## Meeting note

<b>Project</b>	AQUIND Interconnector
<b>File reference</b>	EN020022
<b>Status</b>	<b>FINAL</b>
<b>Author</b>	The Planning Inspectorate
<b>Date</b>	28 August 2019
<b>Meeting with</b>	Aquind
<b>Venue</b>	Telecon
<b>Meeting objectives</b>	Project update meeting and review of draft documents
<b>Circulation</b>	All attendees

### Section 51 Advice – draft Application Document by AQUIND Limited for PINS review

CONTINUED ON SHEET 2

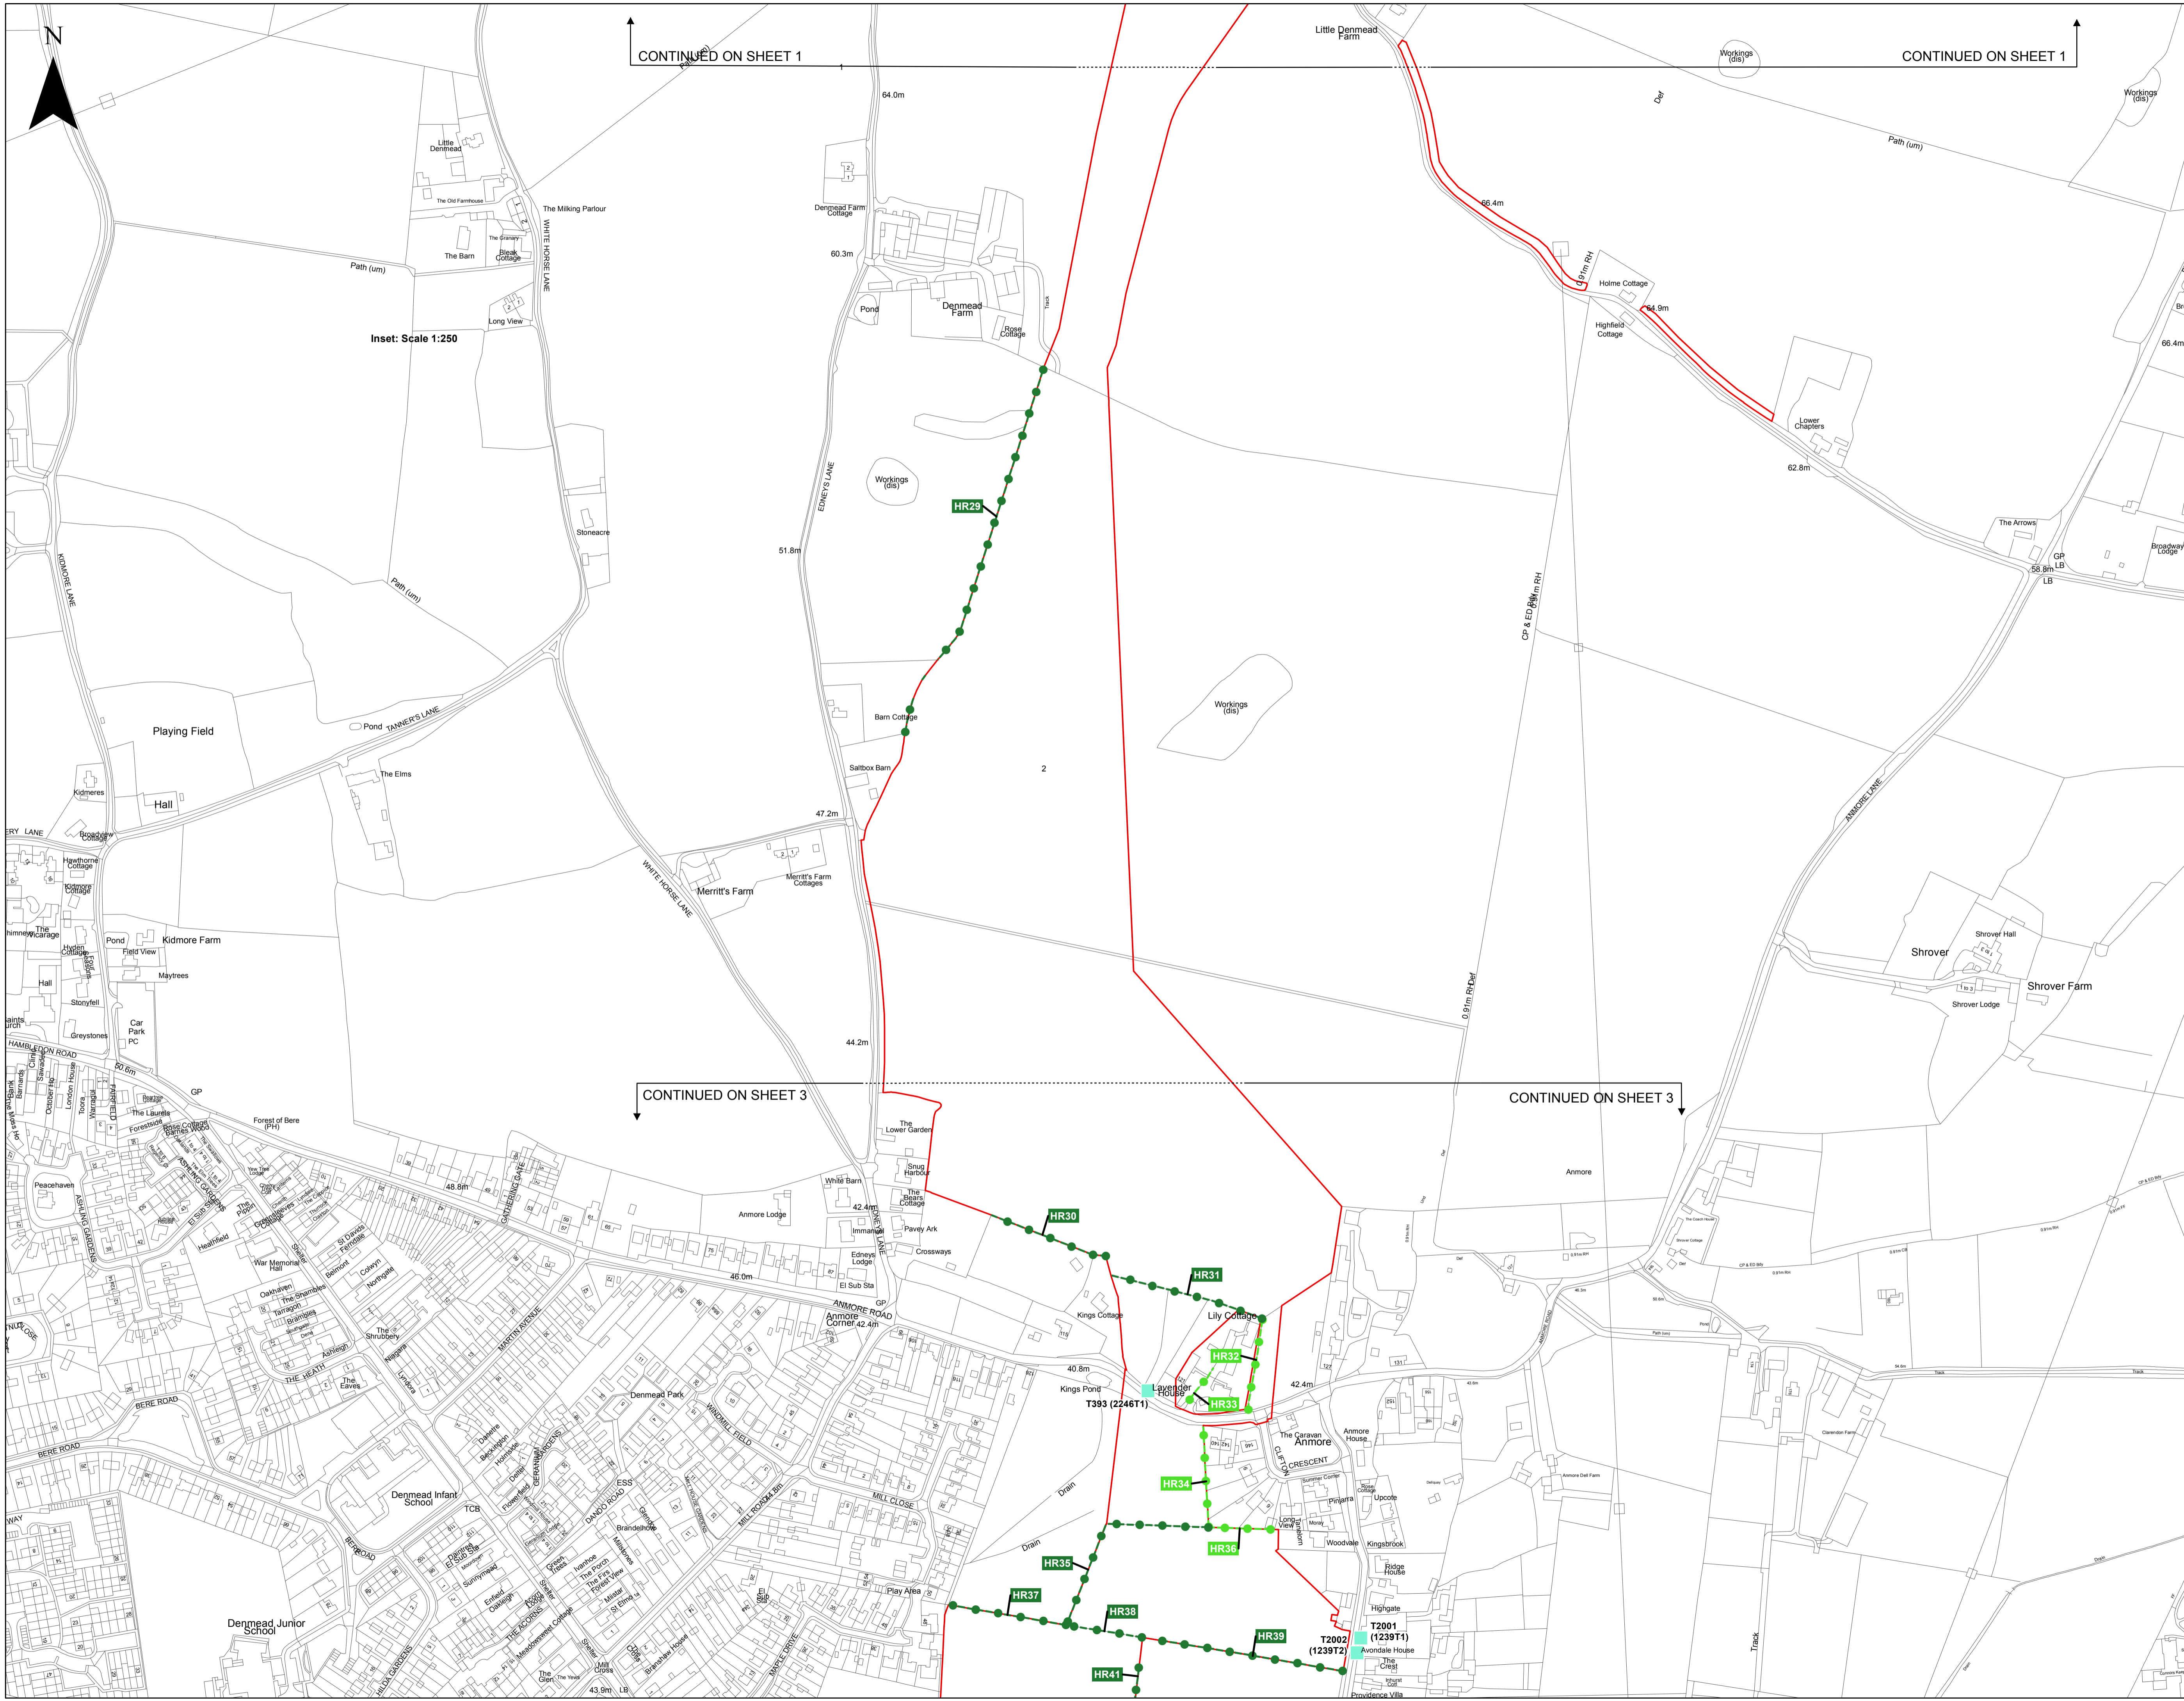
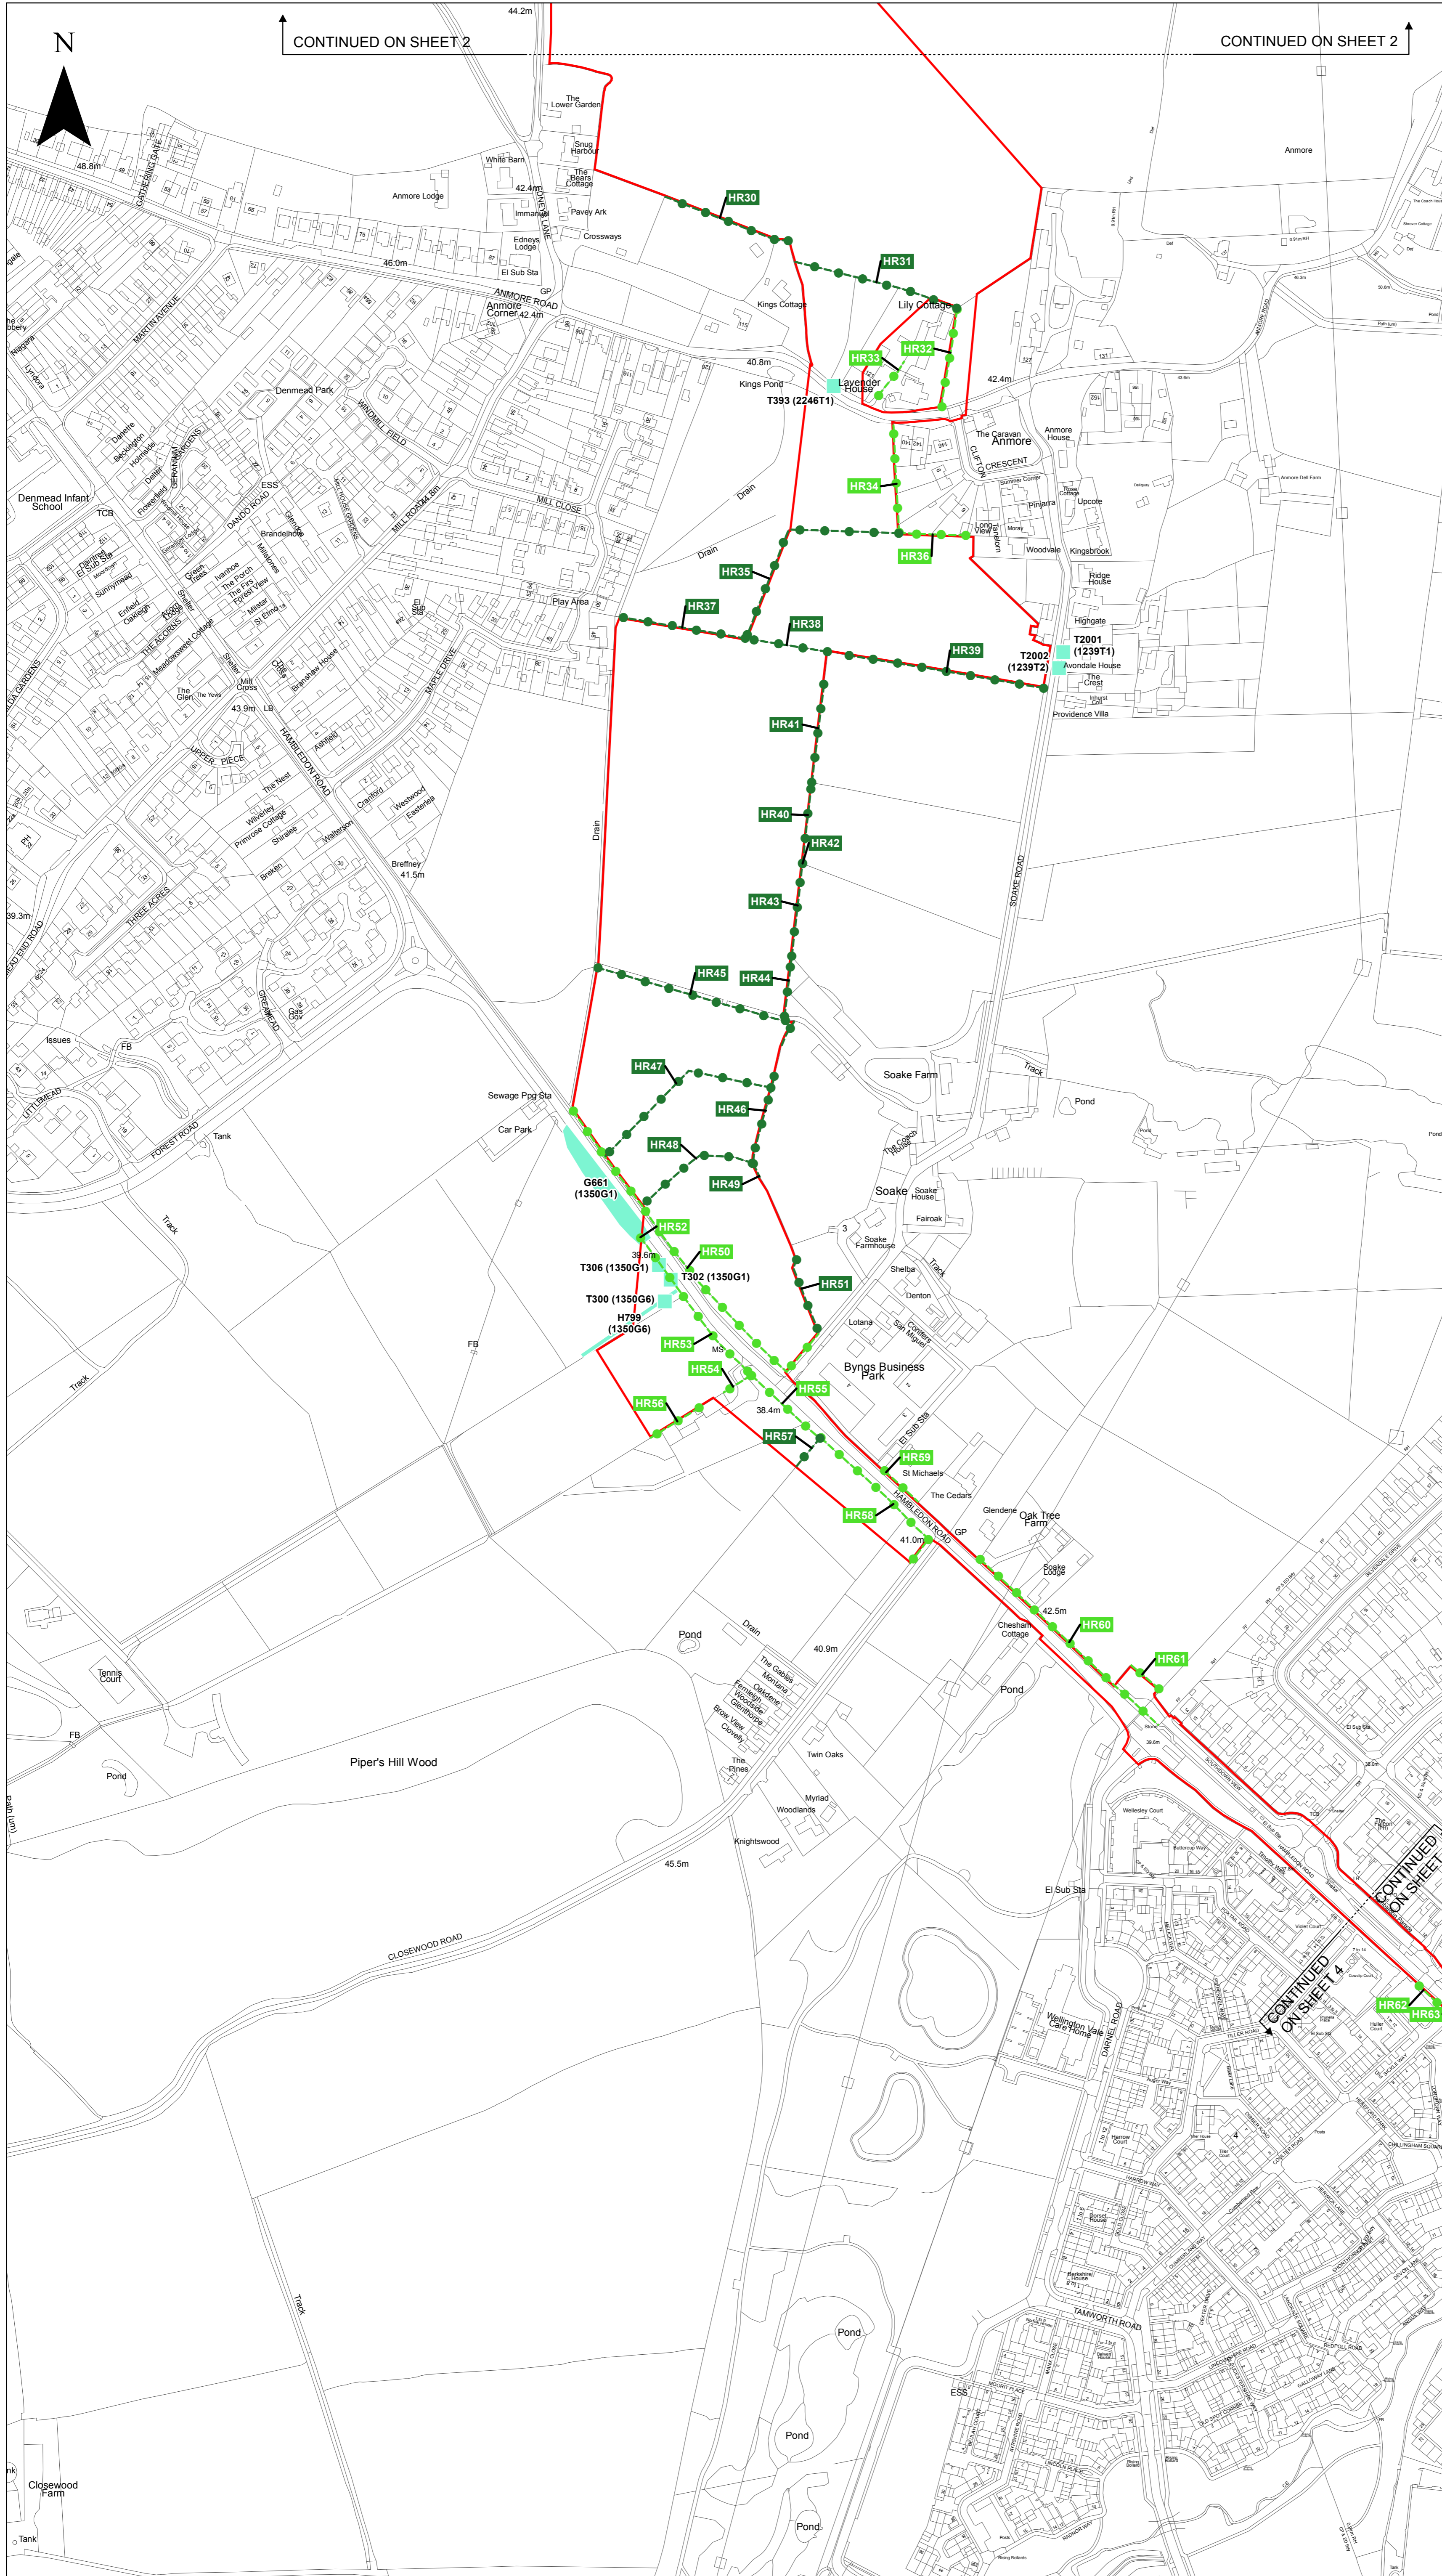
12.	Article 40(4)(a)	Felling or lopping of trees [and removal of hedgerows]	Please refer to AN15 where it states that 'Hedgerows affected by the Proposed Development should be identified in a Schedule to and on a plan accompanying the draft DCO. The Schedule and plan could also helpfully identify those hedgerows that are 'important' hedgerows.

Draft Development Consent Order			
Q No.	Article (A)/ Requirement (R)	Extract from DCO (for ease of reference)	Comment/Question
			Therefore it is advised that all hedgerows are identified in a schedule, and not just important hedgerows.
